DECISION DELEGATED TO HEAD OF PLANNING

Application No: H14-0454-26 **Applicant:** Dorset Carpentry & Building (Mr S Twelves)

Proposal: Two Storey Side Extension and Single Storey Utility Extension

Location: Sunnyside Langhole Drove Pinchbeck

Elevation 01 - Front
1 : 100

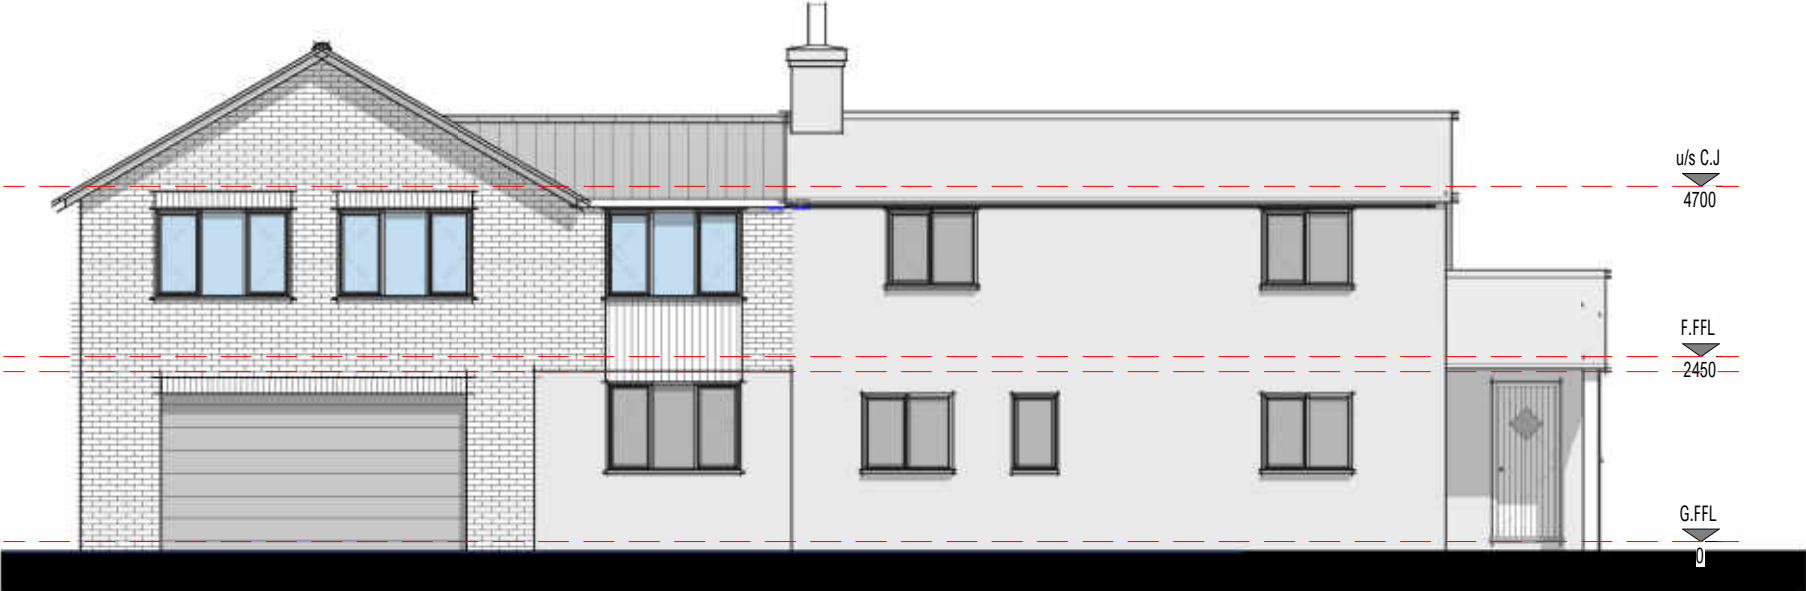
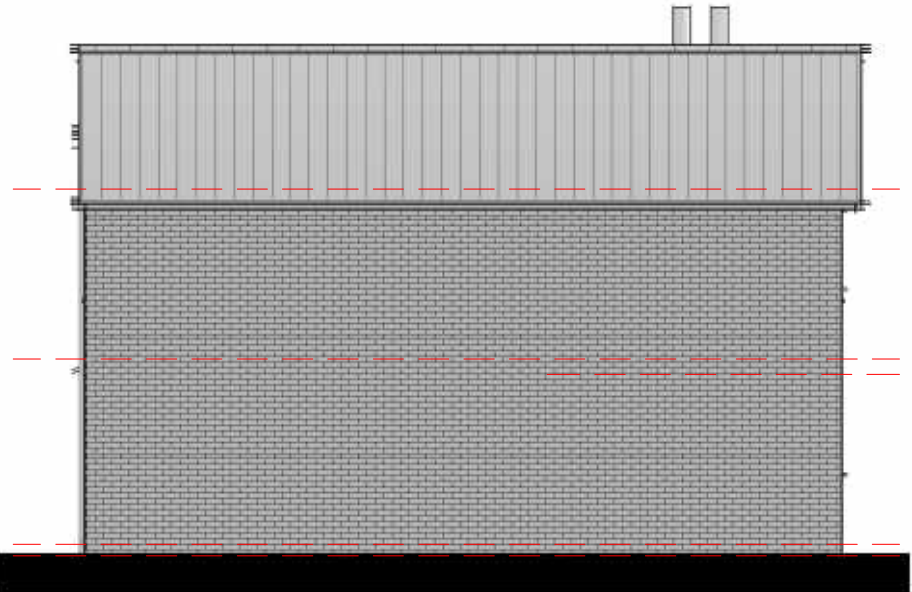
The proposal would significantly increase the perceived bulk of the dwelling. This is particularly acutely felt due to the visibility of the extensions and the relationship with the host, including the ridge height of the extension being greater than its host. As a result, it is considered that the resultant dwelling would look overly large and bulky in its setting, and would fail to be proportionate to its plot.

The two-storey extension itself, taken in isolation of the wider area, would fail to respect the existing proportions of the dwelling. The increase in ridge height would result in the extension appearing unduly dominant, and failing to create the typical subservient host and extension relationship.

Block Plan
1 : 500

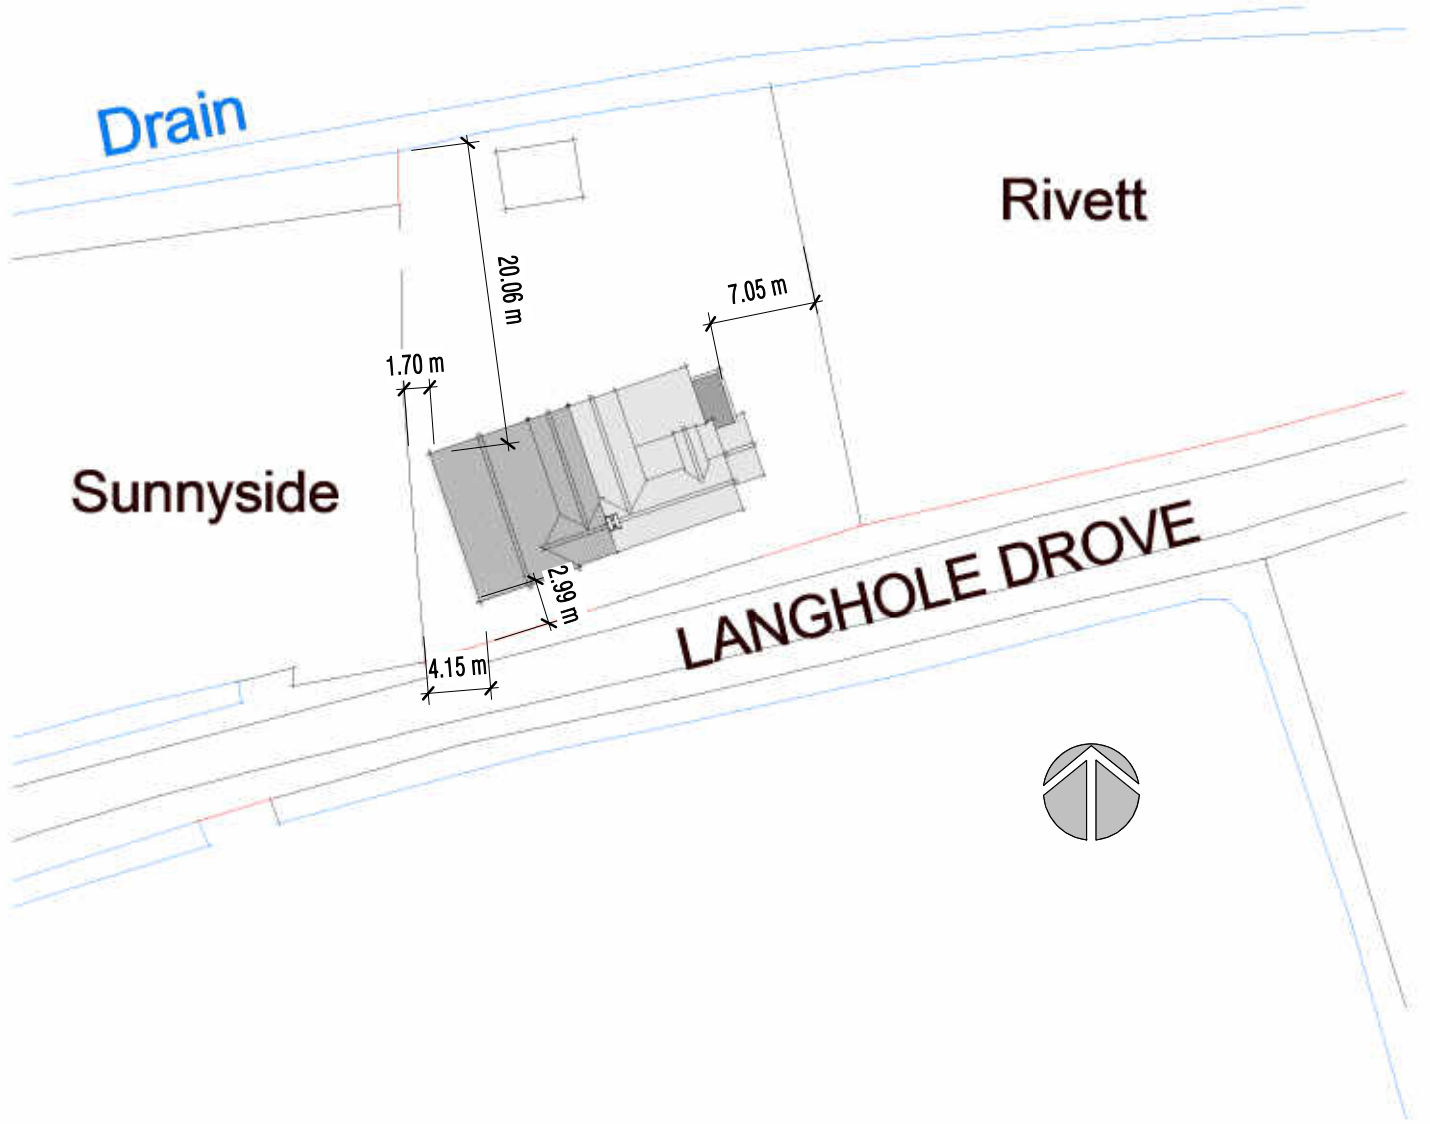
Additional information required - Please ask if the applicant intends to retain the existing vehicle access to the east of the dwelling as if not this should be stopped up. The proposed vehicular access within the public highway will need to be constructed to Lincolnshire County Council specification under a Section 184 agreement. Please request that the applicant add a note to the site plan stating as such, so that it forms part of the approved drawings.

Adequate on site parking would be maintained. The comments of the Highway Authority are noted. However, the Application Form has stated that no new access would be created. The application therefore does not relate to the formation of a new access, and therefore this matter is not relevant to the extension proposed.
